PLANNING AMENDMENT

Application No. H03/0654/03/H1

Description: New pitched roof over whole house with access to
roof space area and conservatory to rear

Amendment: Front & rear dormers reduced from three to two
Dwg.no. 116:4A

Drawing
SKETCH DESIGN
(ELEVATIONS) **116:4A**

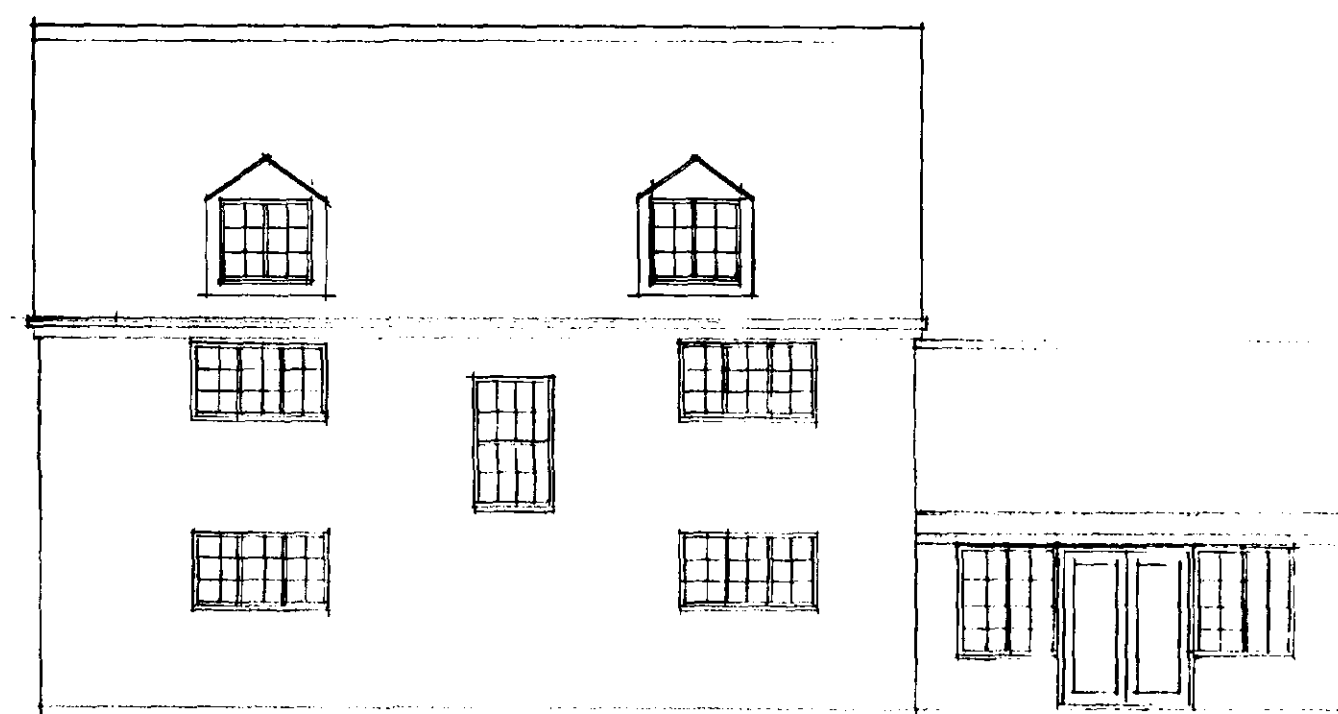
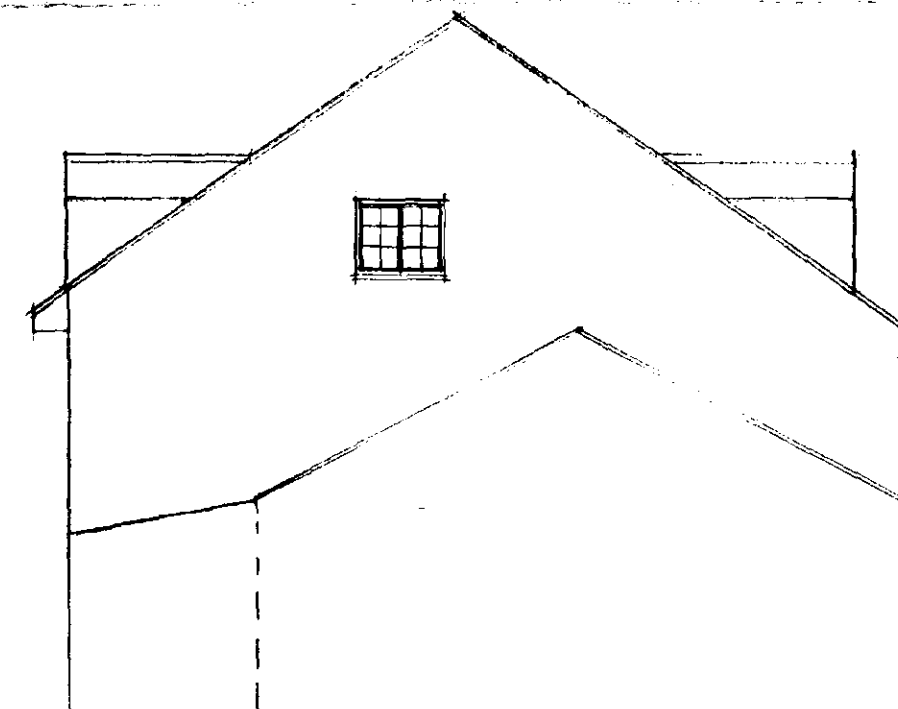
With reference to the above Planning Application I now enclose 5No copies of my amended drawing showing the elevations with 2No Dormers to front and rear instead of 3No originally shown.
